Attachment A - Liverpool Hospital Integrated Services Building SSD10389 – Response to Request for Additional Information

DRAWING  
SECTION THROUGH CAMPBELL  
STREET  
PRINT DATE  
5/11/2020

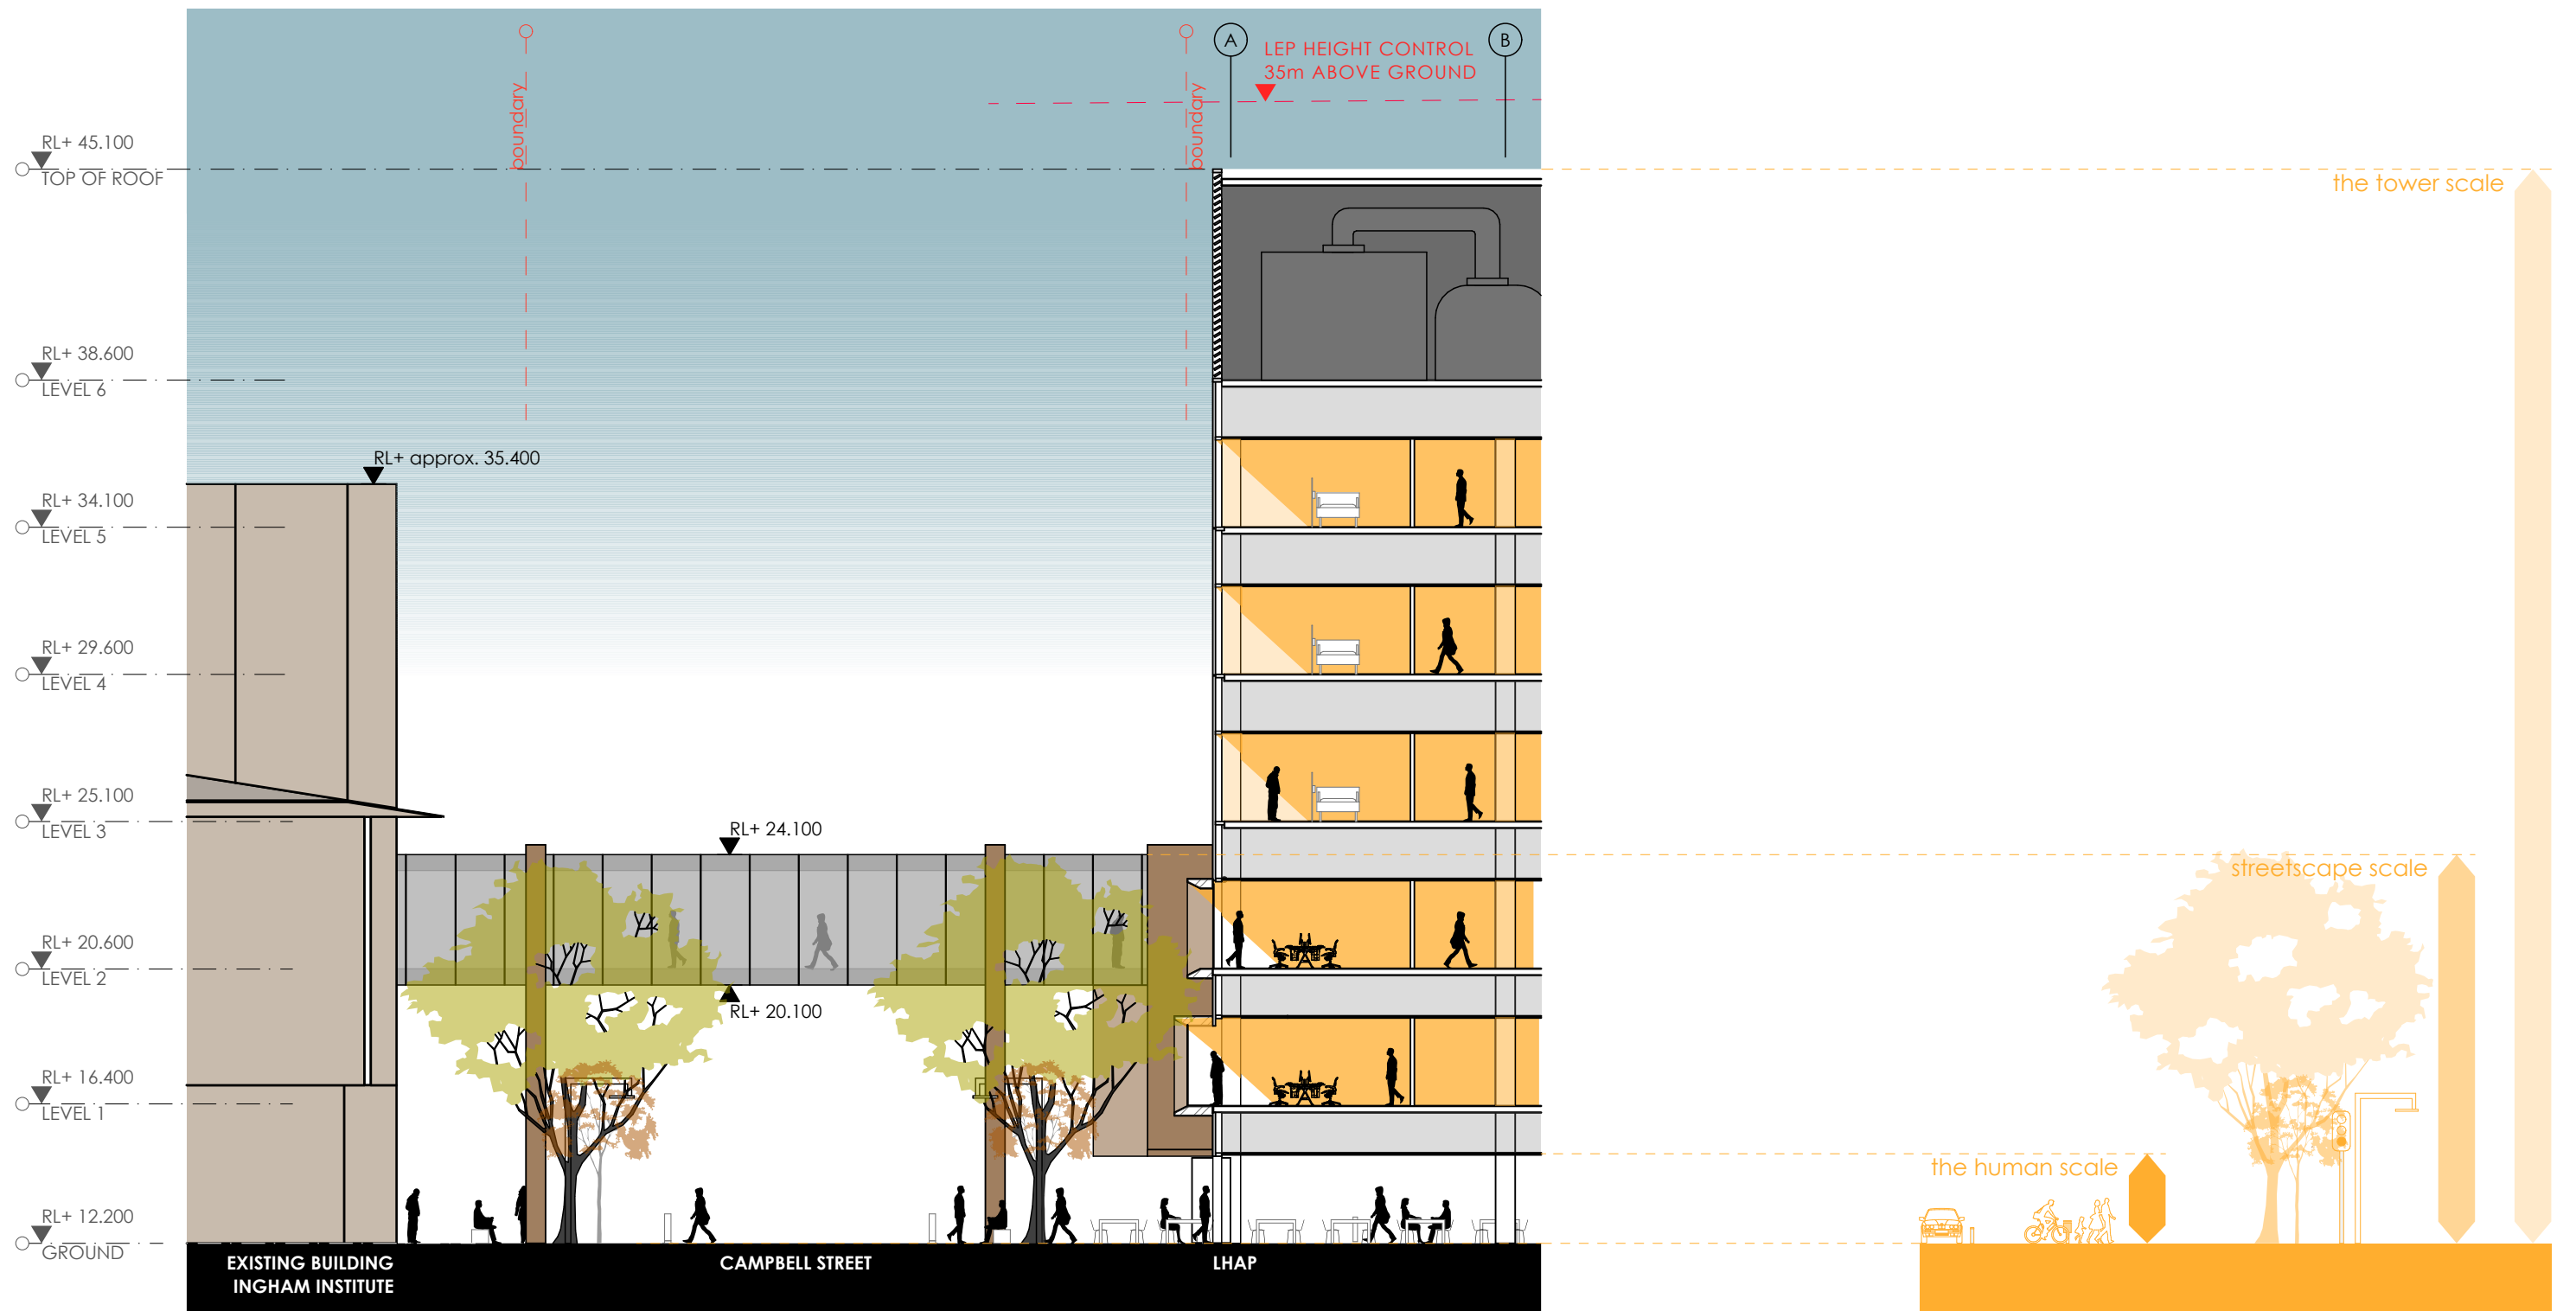
Liverpool City Council	
Traffic Planning Consideration Council supports the intended objective of the proposed shared zone to create a more pedestrianised area which complements the active frontage proposed as part of the redevelopment. However, a number of concerns in relation to the proposed shared zone along Campbell Street were identified in our previous letter:	<p>The project aims to minimise vehicular traffic in this section of Campbell Street to facilitate pedestrian connection between Liverpool Hospital and the proposed Education and Research Hub building and the broader education and research zone to the north of Campbell Street in accordance with the Liverpool Innovation Precinct Land Use Strategy. The expectation is that traffic will find an alternate route, as assessed in the Transport and Accessibility Impact Assessment prepared by GTA Consultants.</p> <p>Please note that the pedestrianisation of Campbell Street is fundamental to achieving the vision of the Liverpool Innovation Precinct (LIP), promoting investment and employment in Liverpool (ref.</p>

<p>a) The proposed street narrowing design will reduce the existing operational capacity of Goulburn Street/Campbell Street signalised intersection and result in a long queue and delays along Campbell Street East.</p>

<p>It is considered that the GTA response letter dated 4 September 2020 has not adequately addressed the above concerns. Council is therefore not in a position to provide an "in principle" support to the proposed shared zone concept along Campbell Street as the concept requires approvals from TfNSW, the bus operators and the Liverpool Boy and Girl high schools.</p> <p>Council requests that every attempt is made to address these concerns. In the event that shared zone is unachievable in the form proposed, it is recommended that the applicant investigate alternative treatments to the roadway so as to balance traffic concerns with the intended objective of the shared zone.</p>	<p>TfNSW have reviewed the proposal and responded in writing to DPIE on 6 July 2020 and 30 Sep 2020. The TfNSW review includes internal consultation with Infrastructure and Services, who are responsible for the respective bus contract region. As noted on page 46 of Transport and Accessibility Impact Assessment prepared by GTA Consultants, further consultation would in any event be undertaken as part of the Section 138 Approval under the Roads Act.</p> <p>A workshop was held with Council on 3 August 2020 to discuss the Campbell Street Shared Zone proposal and associated works. Council indicated in-principle support for the Shared Zone and change in priority at the Lachlan Street/Forbes Street intersection, subject to investigation of kerb extensions to improve pedestrian safety and detailed design resolution as part of the Section 138 approval required prior to commencement of the road works. It is expected that the S138 process will require the design to be reviewed via Council's Traffic Committee which includes Council and TfNSW in any event, ensuring the outcome sought by Council is achieved.</p>

<p>It is recommended that the Department include a condition confirming that only the concept of the shareway is approved and the detailed design of the shareway would be subject to further approval under Section 138 of the Roads Act.</p>
<p>The SIDRA modelling analysis indicates that Lachlan Street/Goulburn Street intersection will be operated at its capacity (i.e. Degree of Saturation at 1.0) under post development AM peak hour network operation with Campbell Street shared zone scenario. It is noted that the DoS of this intersection has dramatically changed to 0.12 under the mitigated Forbes Street/Lachlan Street intersection layout scenario. It appears some discrepancies in the modelling results presented in the GTA letter.</p> <p>As such, an electronic copy of SIDRA network models and a tech memo outlining the modelling assumptions are to be submitted for review. The submitted models should include the following intersections which are assessed in the traffic impact assessment report and GTA response:</p> <ol style="list-style-type: none"> Elizabeth Street/Goulburn Street intersection; Lachlan Street/Forbes Street intersection; Lachlan Street/Goulburn Street intersection; Campbell Street/Goulburn Street intersection; and Lachlan Street/Burnside Drive/Hart Street intersection. 	<p>The SIDRA modelling results are correct. To clarify, Lachlan Street/ Goulburn Street is anticipated to operate at a degree of saturation of 1.0 with the shared zone based on the existing intersection layouts. This is due to the existing Forbes Street/ Lachlan Street intersection having stop sign controls on the Lachlan Street approaches. Once traffic is diverted from Campbell Street to Lachlan Street due to the implementation of the shared zone, the existing stop control at the Lachlan Street/ Forbes Street intersection would ultimately result in queues extending back to the Lachlan Street/ Goulburn Street intersection, significantly impacting the operation of this intersection without further mitigation.</p> <p>The proposed mitigation measures involve reversing the priorities of the Forbes Street/ Lachlan Street intersection so that Lachlan Street is the major road and the stop controls would be located on the Forbes Street approaches. This modification results in significantly less queuing on the western approach to the Forbes Street/ Lachlan Street intersection and would not impact the adjacent Lachlan Street/ Goulburn Street intersection, thus resulting in a significantly improved degree of saturation compared to the unmitigated scenario.</p> <p>Modelling assumptions for the shared zone analysis are included in Section 9.5 of the Transport and Accessibility Assessment (GTA, 6 May 2020) submitted as part of the SSDA. SIDRA modelling files will be provided to Council.</p>

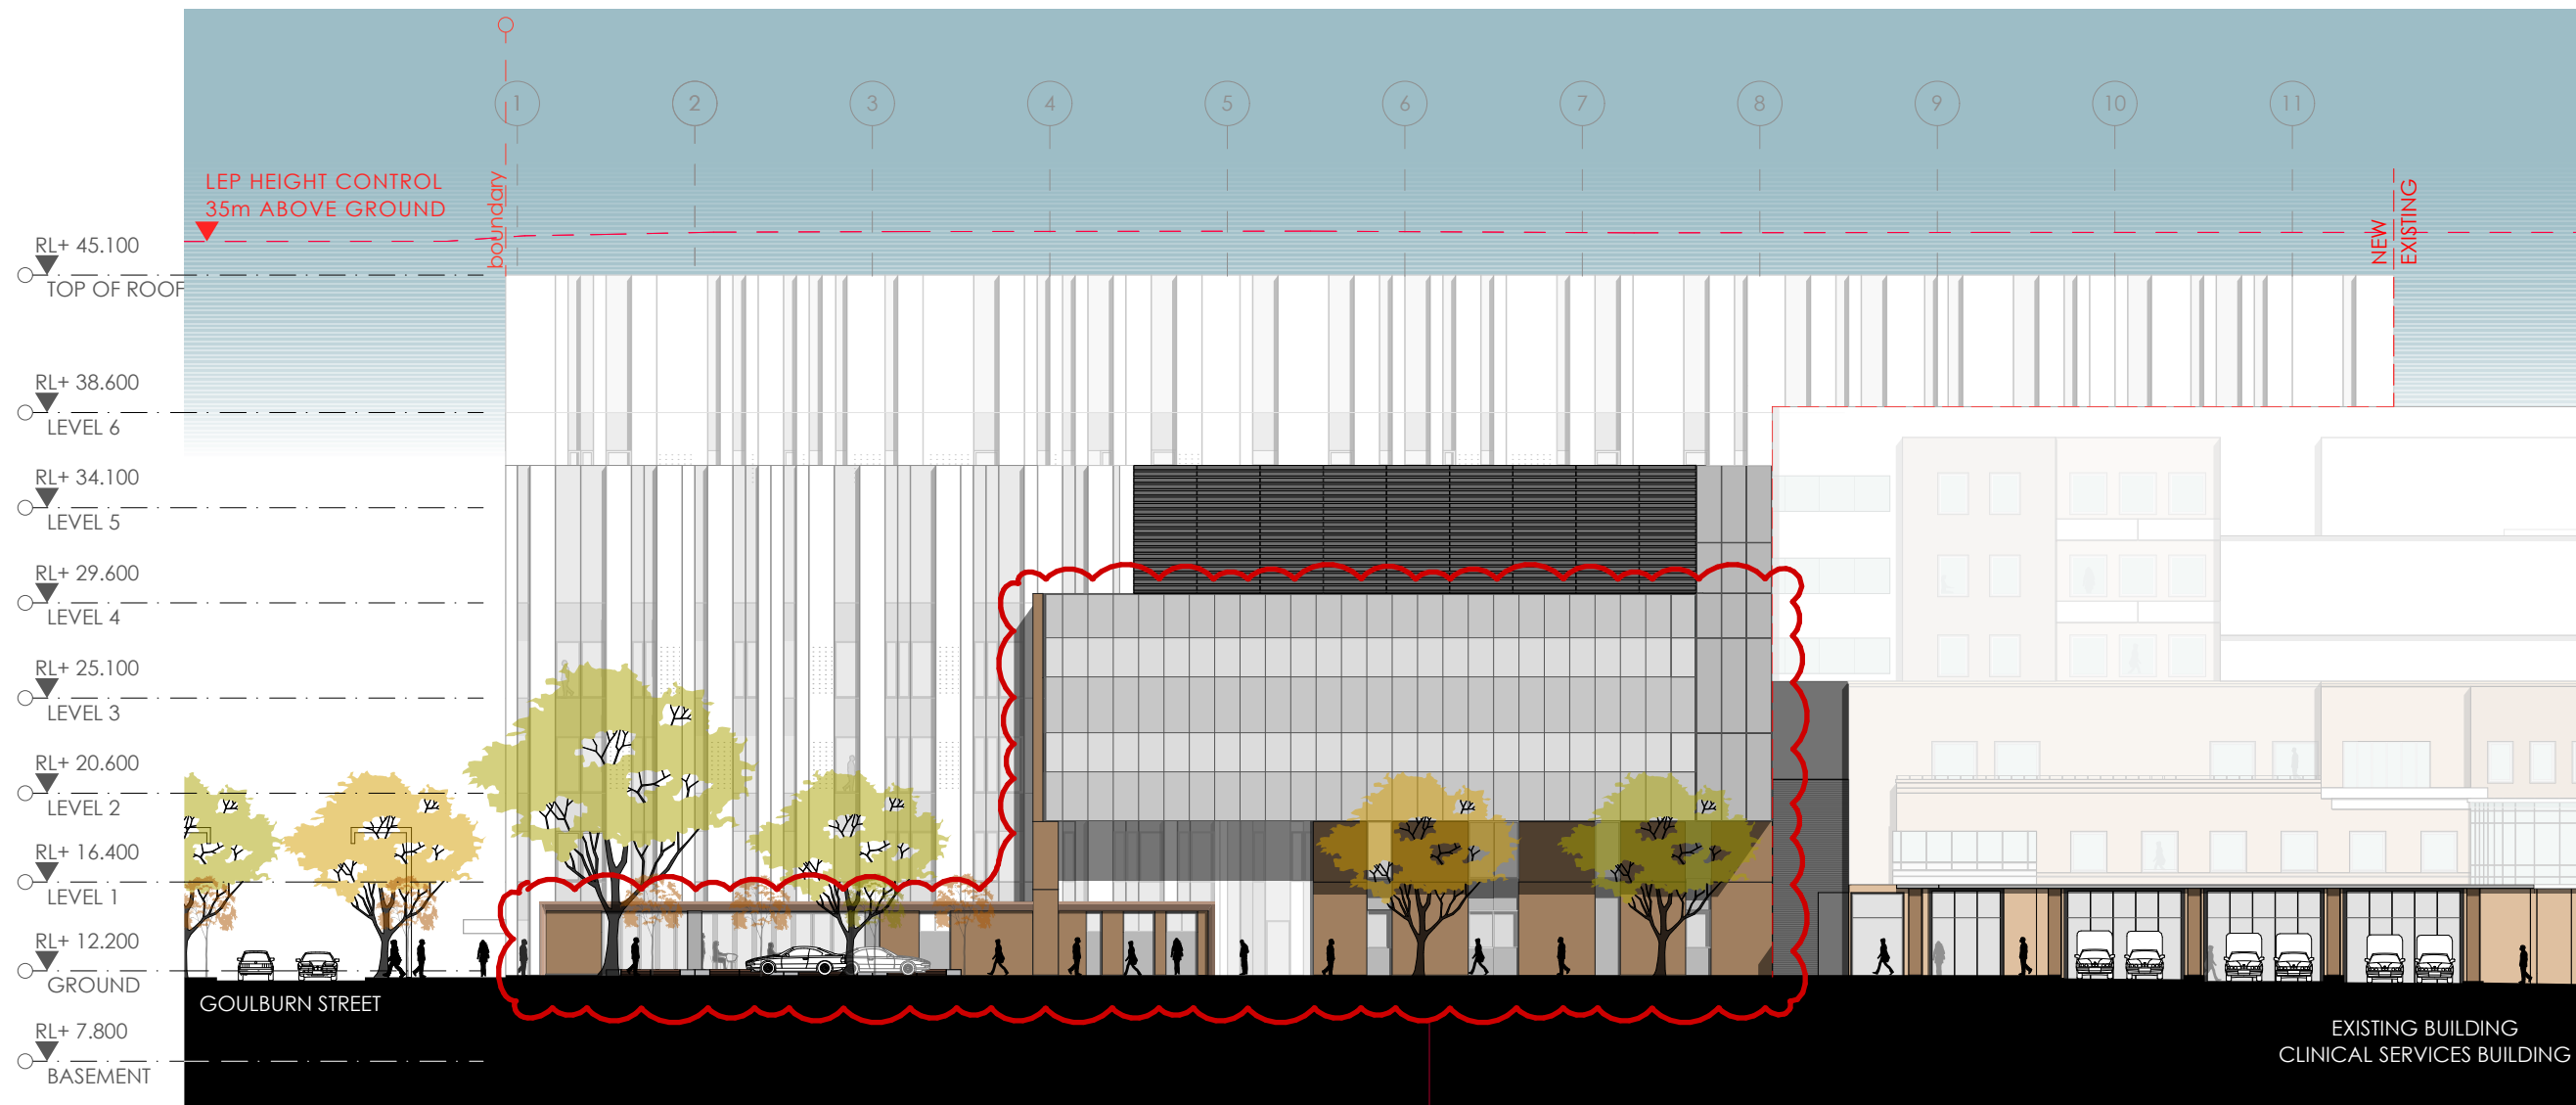
Urban Design Consideration – Aesthetics The amendments to the external façade along the southern side of the hospital building and the existing clinical services building is supported. It is recommended to incorporate vegetation/vertical planting along the proposed colonnade to improve the architectural character and achieve an increased visual amenity.	The proposed development includes significant landscaping and tree planting in the front entrance to provide a high quality public domain and complement the architectural character.
City Economy Consideration Council is encouraged by the plans for wayfinding inside the development. However, it is considered appropriate that the development also contribute to wayfinding in the	The proposed development is on an existing hospital campus site that is not changing location. It is not considered appropriate that HI provide further wayfinding throughout the Liverpool CBD.
